PERMIT NUMBER
BRES2505-0017

Description: 50 x 44 Proposed Duplex (BRES2505-0019)			
Type: BUILDING RESIDENTIAL	Subtype: TWO FAMILY DWELLING OR DUPLEX	Status: APPROVED	Applied: 5/6/2025 DJ
Parcel No: 0690-73-3732.000	Site Address: 40 N CARRIE ST COATS,NC 27521		Approved: 5/28/2025 BS
Subdivision: None	Block:	Lot: 00001B	Issued:
Lot Sq Ft: 0	Building Sq Ft: 0	Zoning:	Finalized:
Valuation: \$0.00	Occupancy Type:	Construction Type:	Expired:
No. Buildings: 0	No. Stories: 0	No. Unites: 0	
Details:

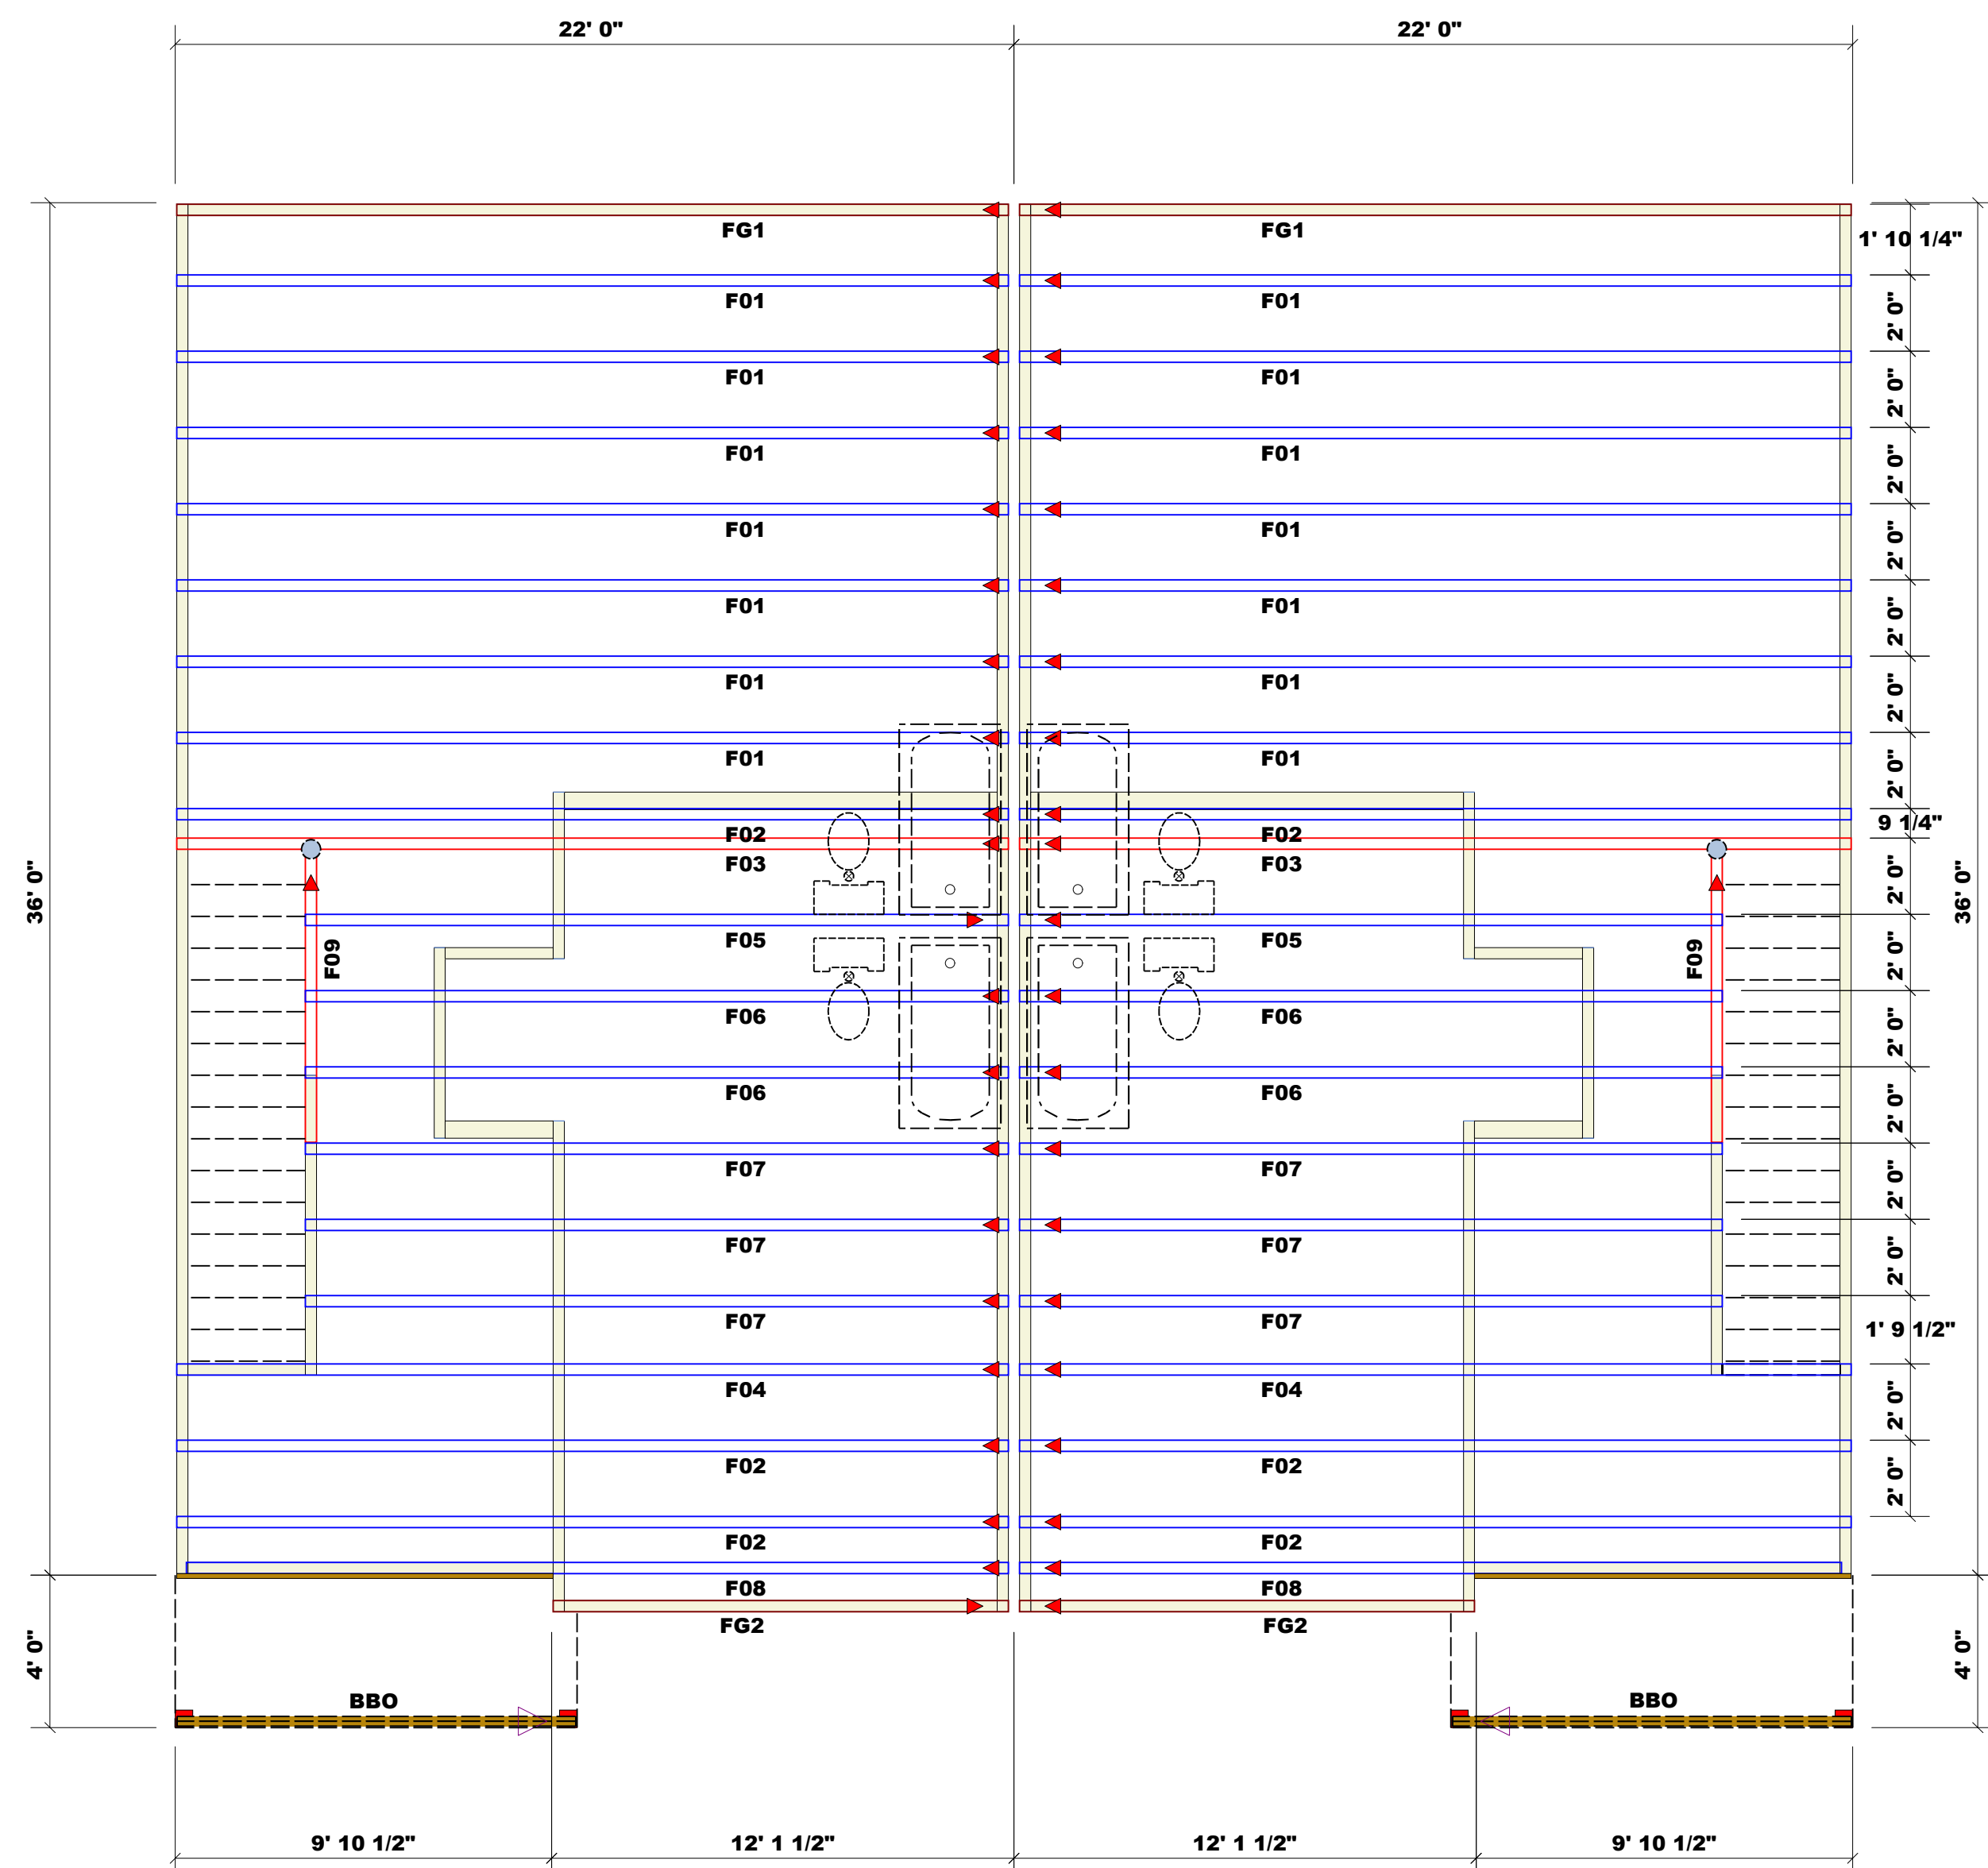
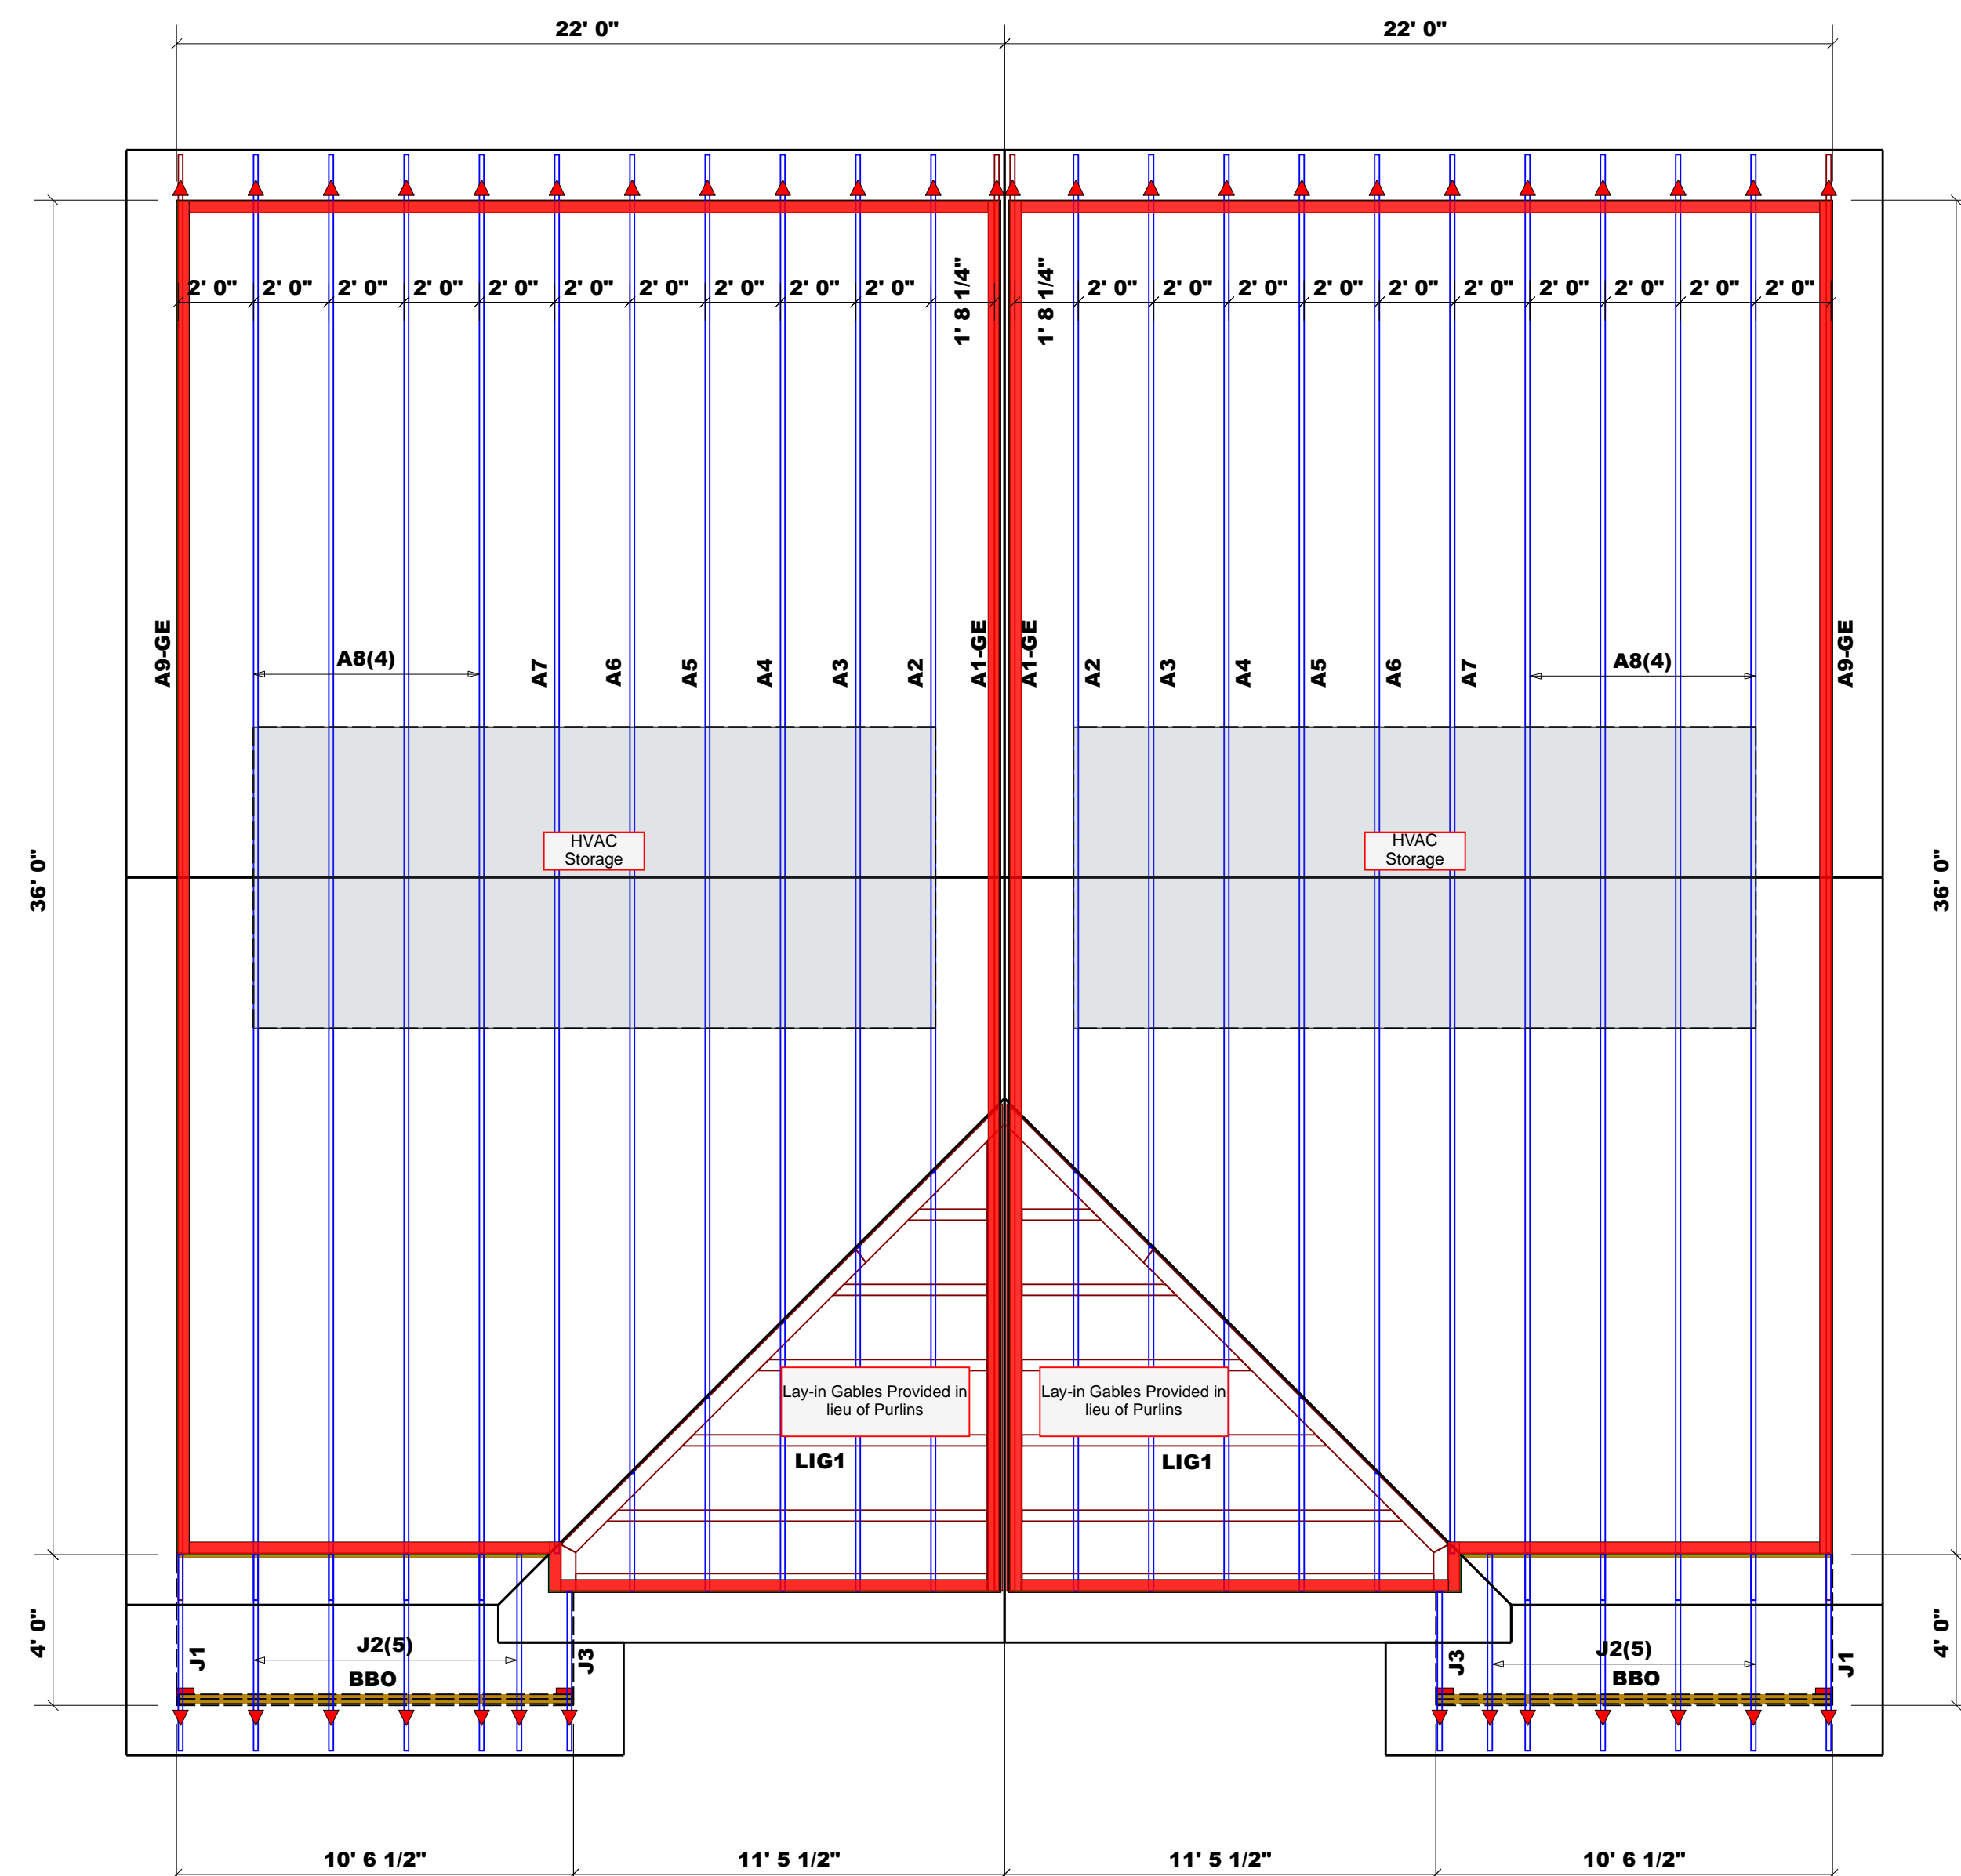
REVIEW TYPE	REVIEWER	SENT DATE	DUE DATE	RETURNED DATE	STATUS	REMARKS	NOTES
CENTRAL PERMITTING INTAKE	CP Bucket	5/6/2025	5/7/2025	5/6/2025	APPROVED		
RESIDENTIAL BUILDING	Brad Sutton	5/6/2025	5/9/2025	5/8/2025	DISAPPROVED		1. Need UL design on firewall. Must be continuous from foundation to roof deck. 2. Need framing layouts for 2nd floor and roof. Provide all beam info
RESIDENTIAL BUILDING	Brad Sutton	5/22/2025	5/28/2025	5/28/2025	APPROVED
